Our Ref: BR/67/22/DOC

Approval of details reserved by condition imposed under BR/281/18/PL relating to conditions 3-site meeting with ADC tree officer & Arboricultural Expert, 7-landscape details & 9-details of new screen walls and/or fences.

99 Victoria Drive Bognor Regis PO21 2DZ

Condition Number 7

PROPOSED SITE/LANDSCAPE PLAN

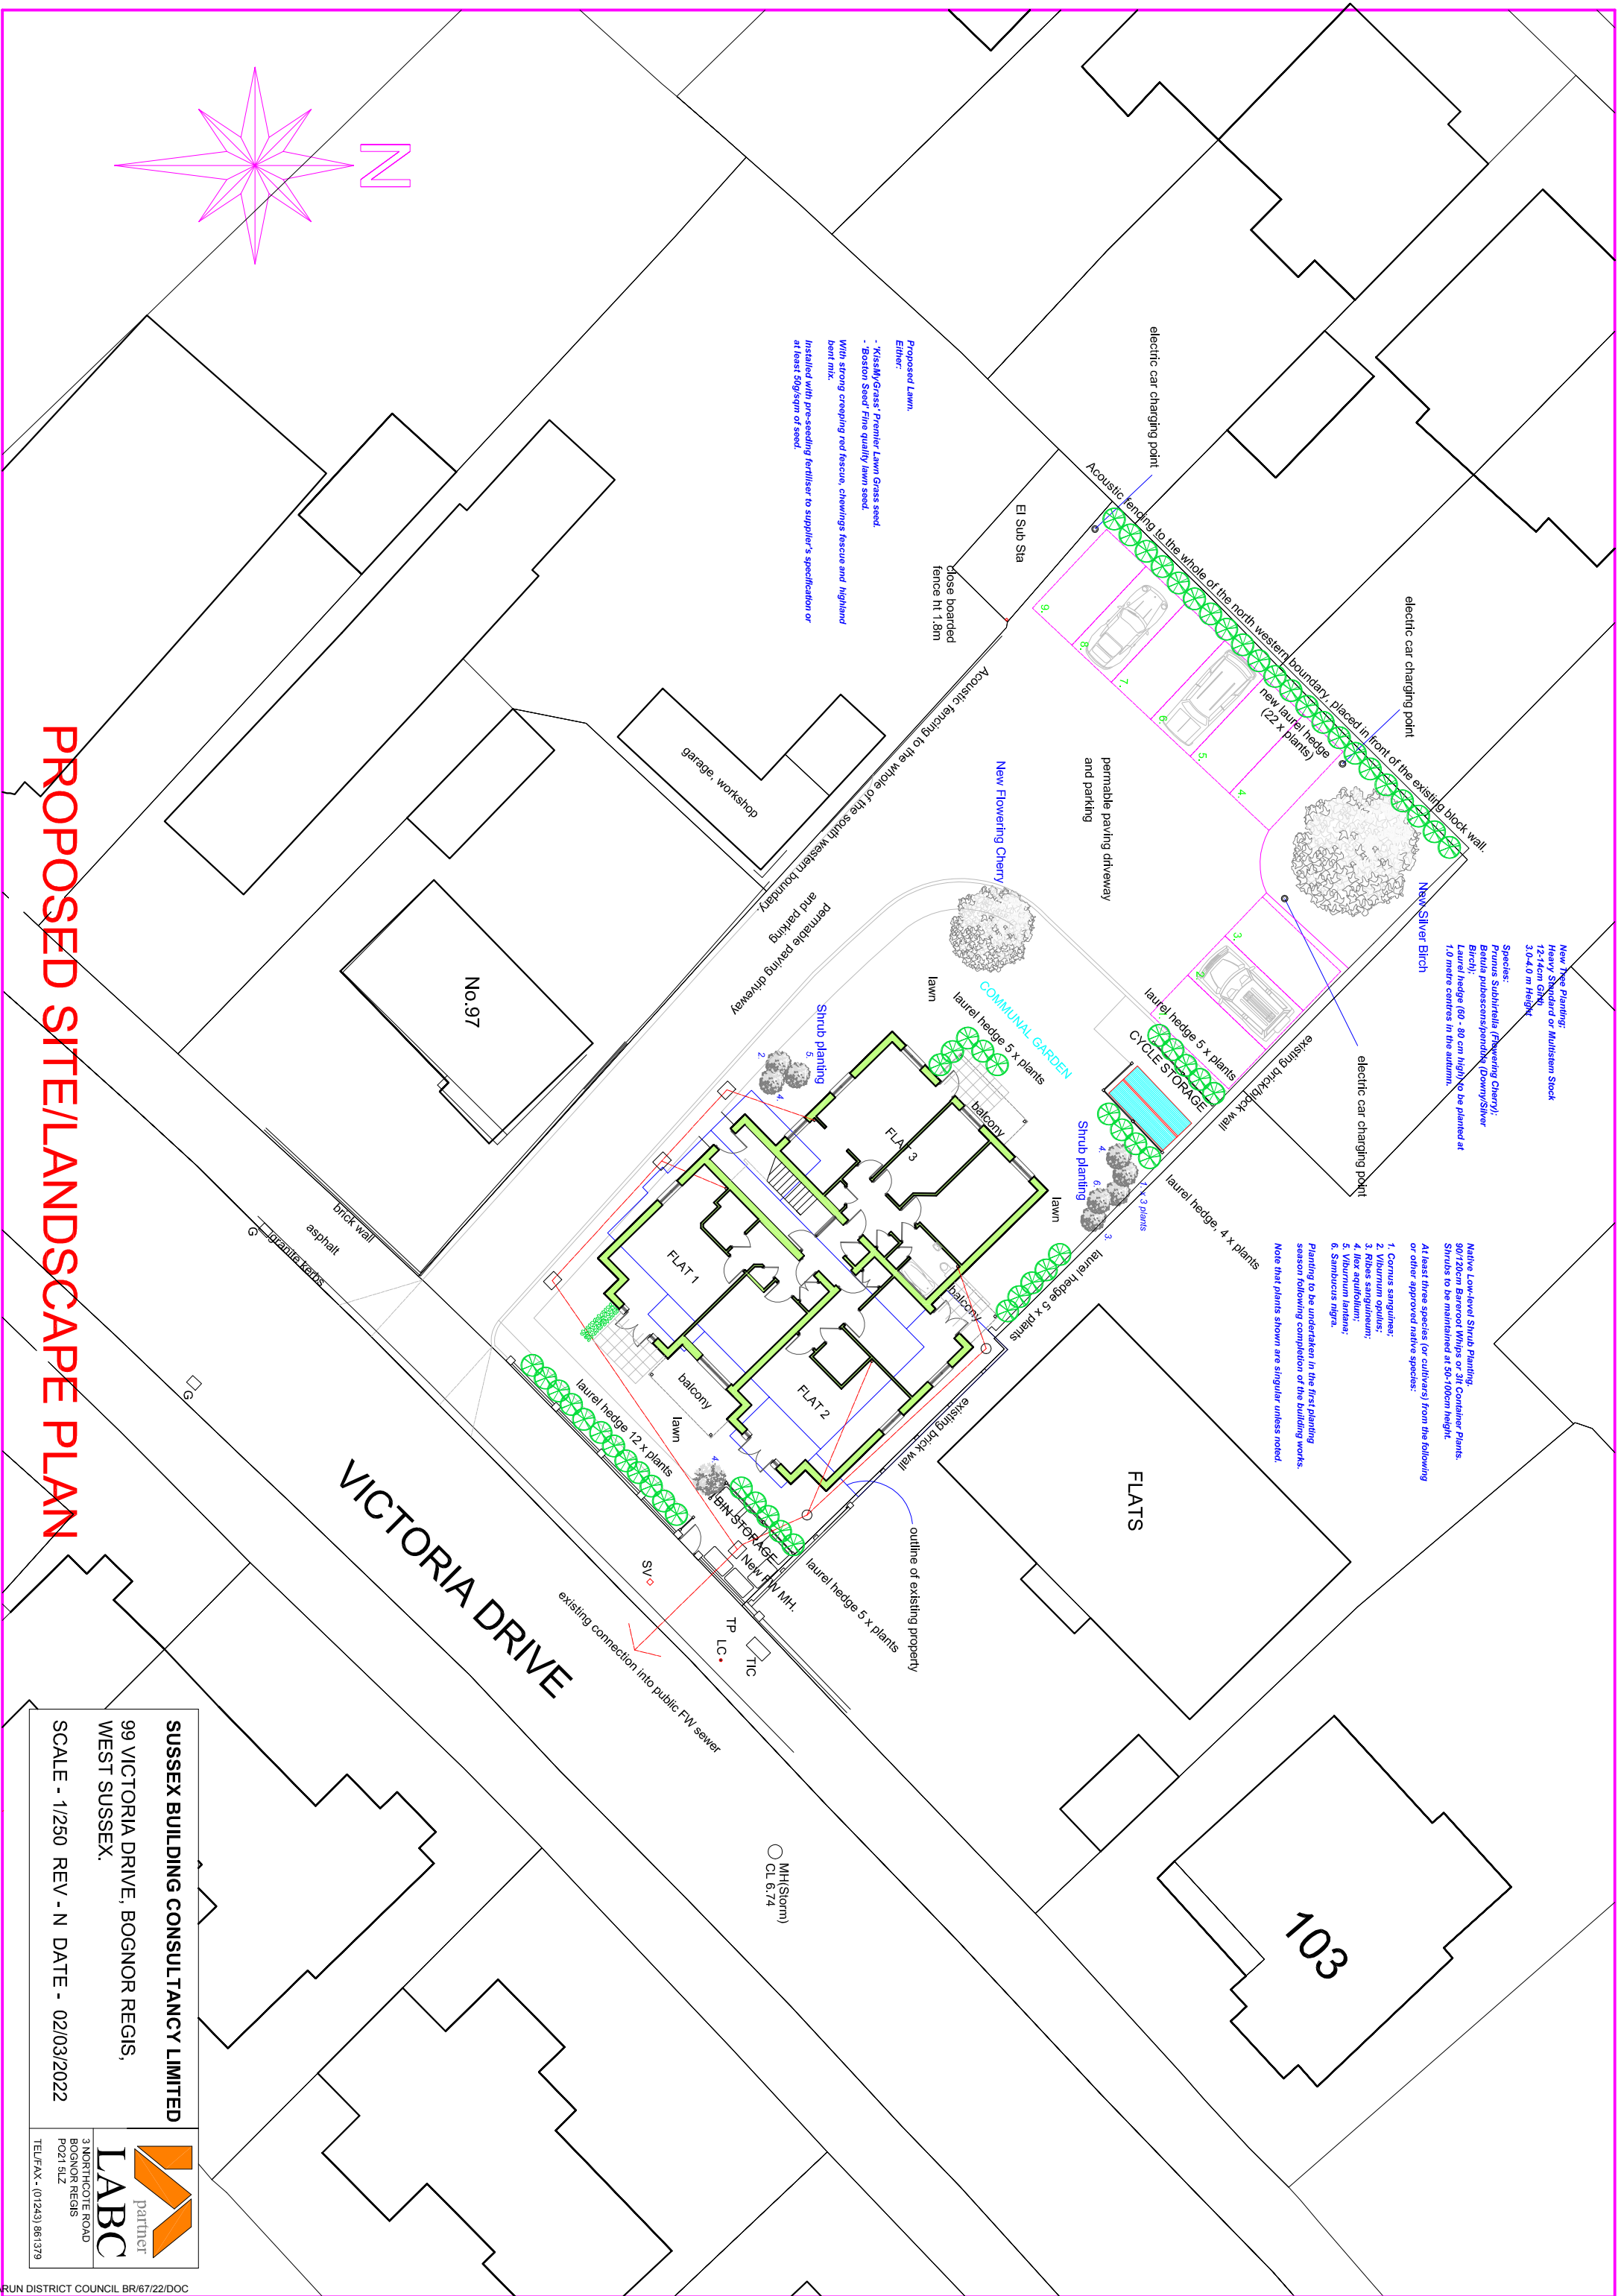
The Council's Landscape Officer advises that the detail submitted under the Proposed Landscape Plan Rev N details a landscape scheme which would be fitting for location and has detailed the proposed planting scheme in plan form with species choice, planting densities and size at time of planting.

The condition is fully discharged in accordance with Proposed Landscape Plan Rev N subject to the further provision of condition 7 regarding planting and replacement planting..
